Review Comments (12)

1 TRASH ENCLOSURE GATE ELEVATION
NOT TO SCALE

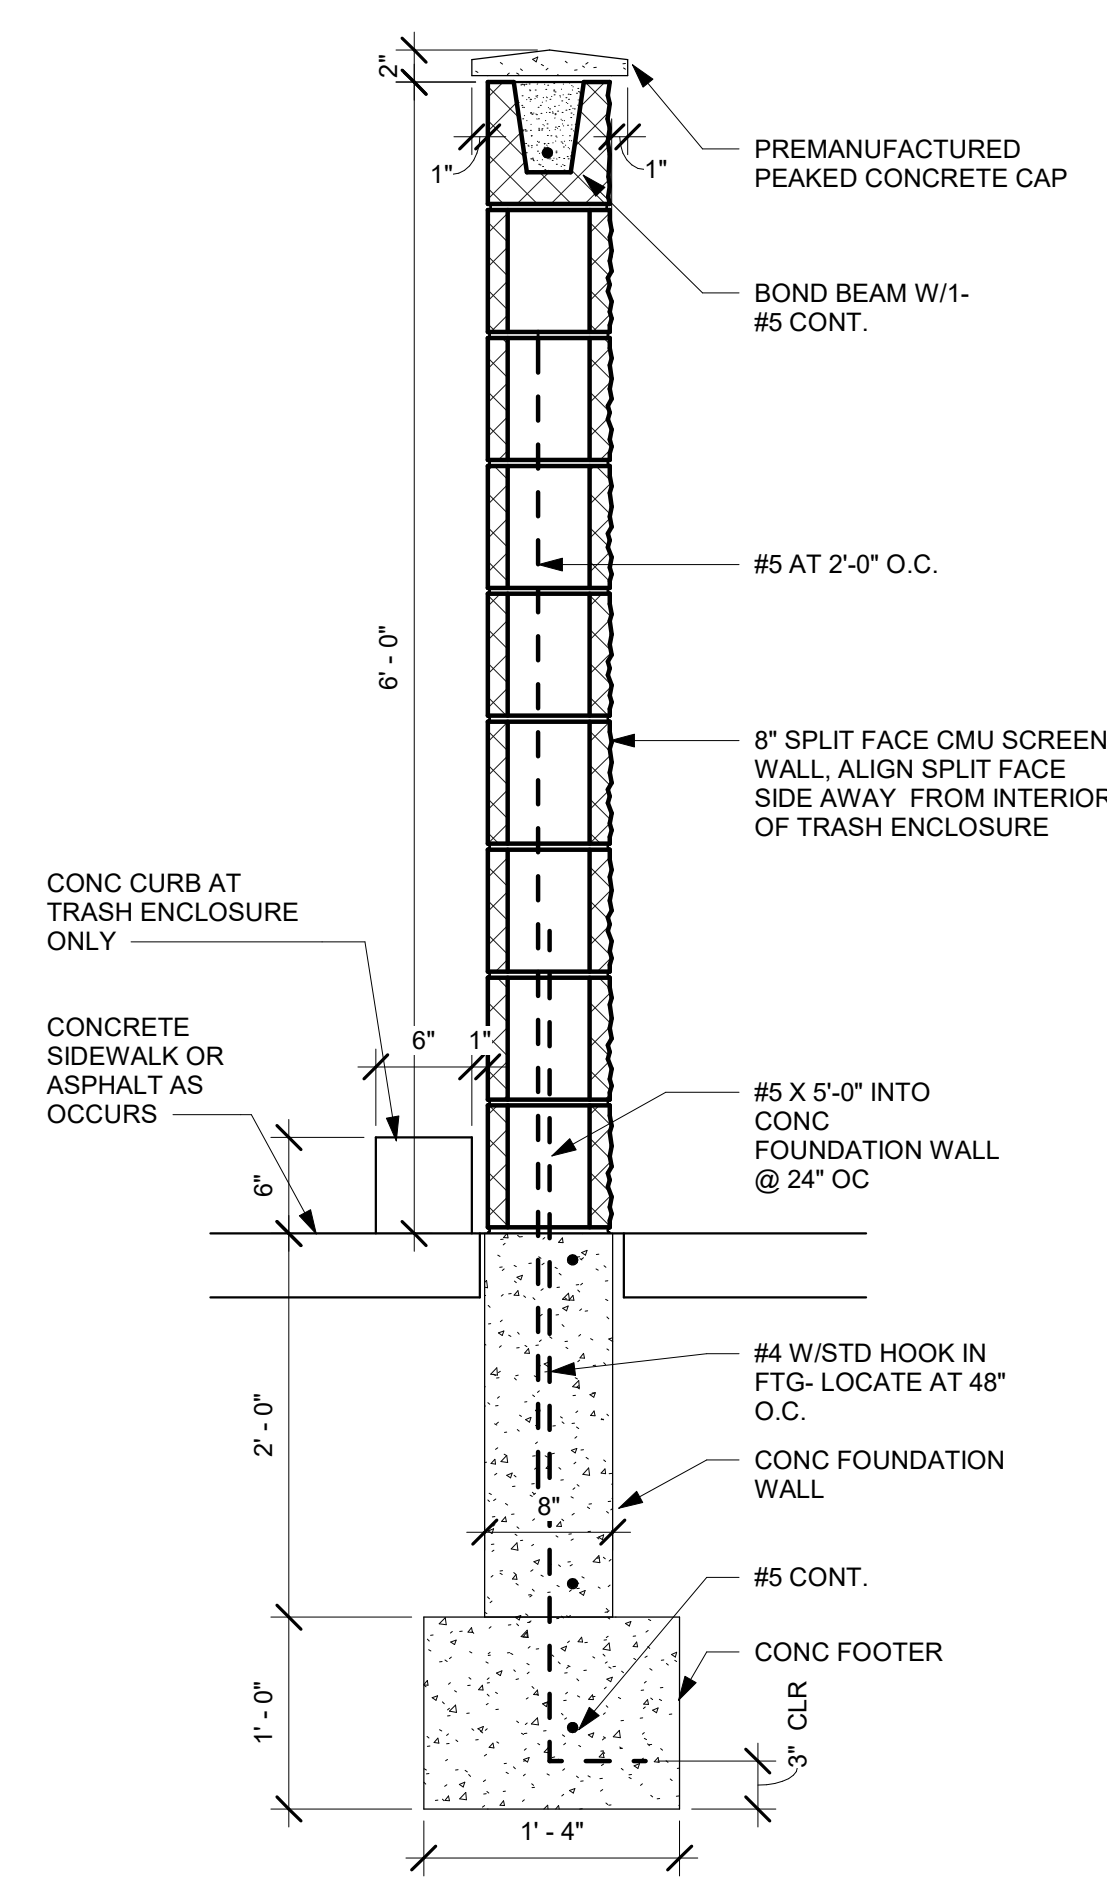
1. Please use 7945 Meridian Park Drive when submitting plans for the storage buildings.
2. It appears the Office building is not attached any of the storage buildings and will use the assigned address 7945 Meridian Park Drive. The concrete storage buildings will have the main address and building letters s
3. The have the mobile homes (temp set) at 116 removed? Enumerations will not approve the pla these have been removed.
4. Any trash enclosures not attached to a building separate address and require a permit.

1. ACKNOWLEDGED.
 2. CORRECT, THE OFFICE BUILDING WILL USE 7945, WITH A STARTING WITH STORAGE BUILDINGS.
 3. ACKNOWLEDGED.
 4. THE TRASH ENCLOSURE PROPOSED IS UNDER 7' IN HEIGHT AND THEREOFRE DOES NOT NEED A PERMIT NOR ADDRESS.
